Application for a Non-Material Amendment Following a Grant of Planning Permission

Single replacement dwelling

DC/22/4046/FUL

TITLE **ELEVATIONS**

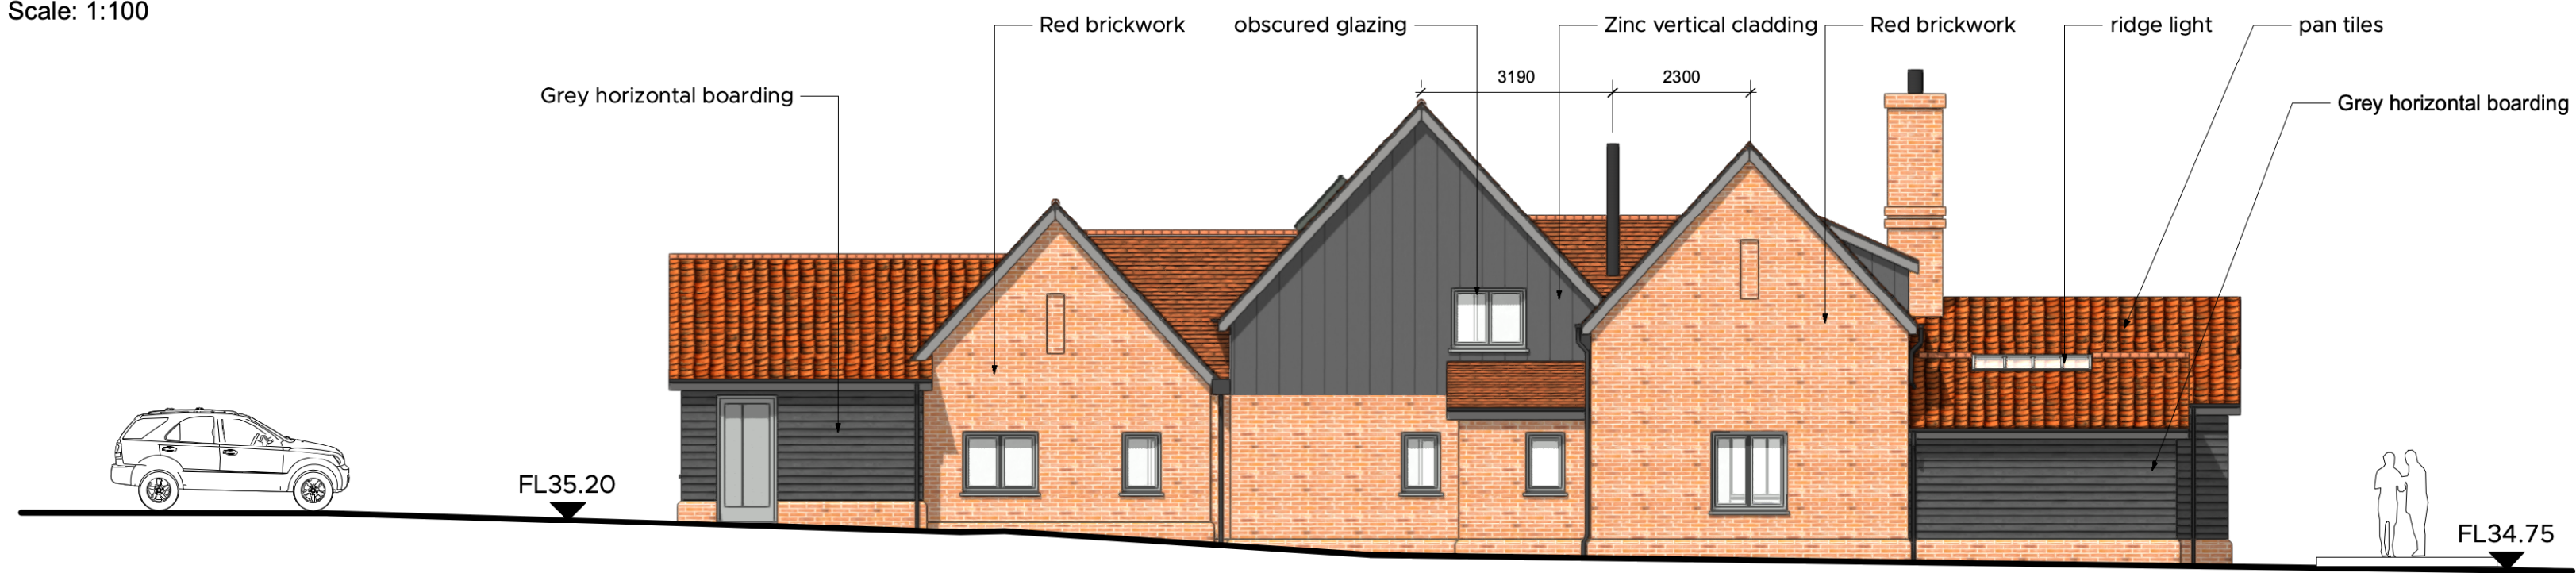
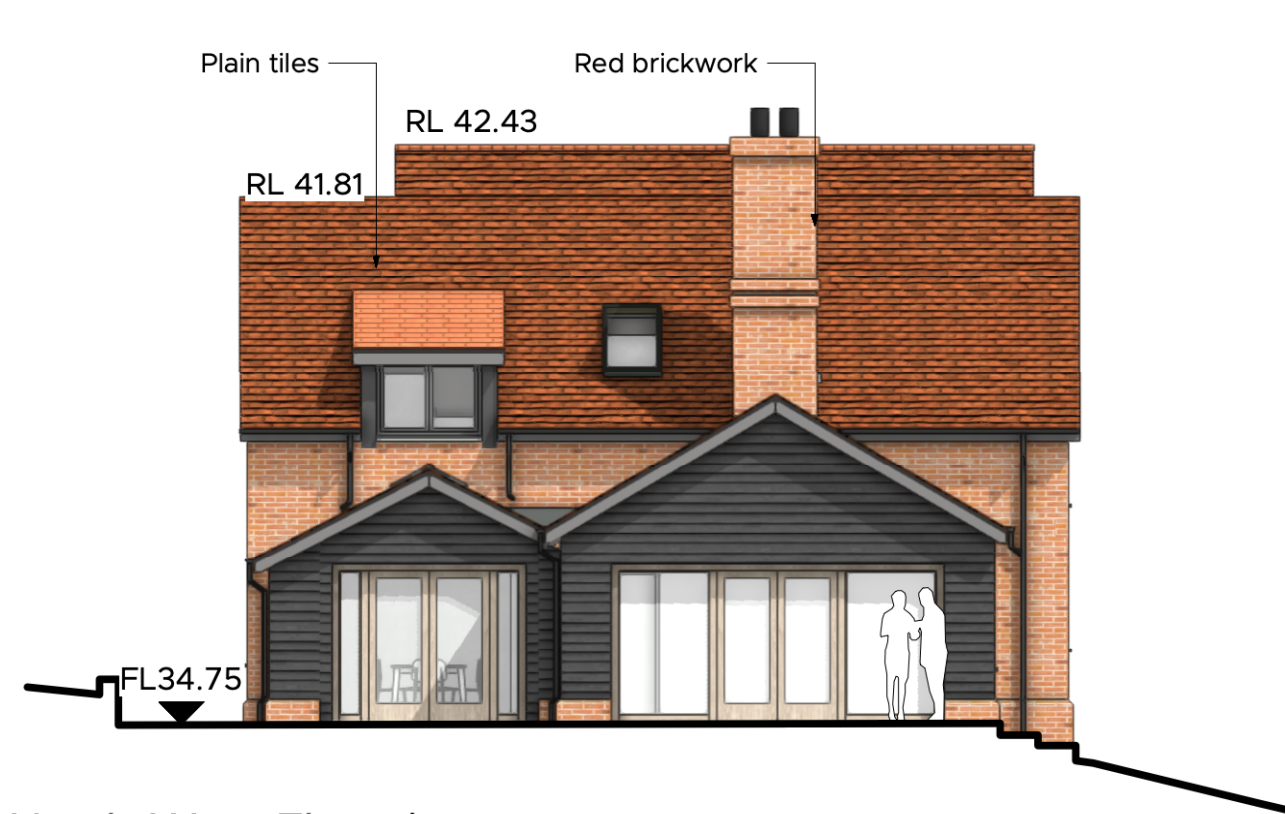
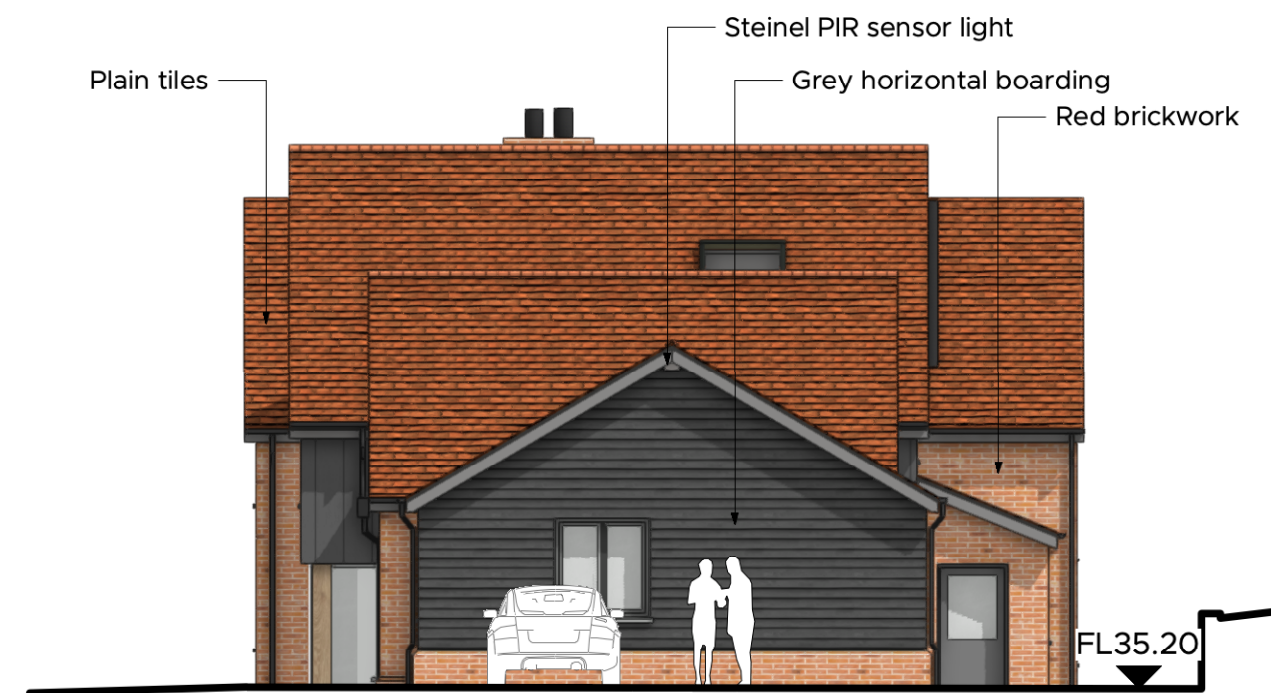
1. Main two storey range narrowed by 200mm and 200mm added to single storey office.
2. S-W elevation wall of Hall, Master Bedroom and Office reduced by 500mm.
3. Plant room wall increase by 1000mm to N-E boundary side.
4. Pan tiles used on single storey roofs at each end in place of plain tiles.
5. A ridge light added over the dining table.
6. Single larger rooflight positioned over staircase rather than two smaller rooflights.

7. Door and window replaces door with side light to office.
8. Brickwork recess detail in bedroom gable end.

9. High level glazing removed.
10. Chimney narrowed.

11. Window omitted from plant room / store.
12. Zinc raised to first floor on central gable end and obscured glazed window moved from central position.
13. Brickwork recess detail added in gable ends.
14. Metal circular flue moved and raised in height.

15. Window added in office.
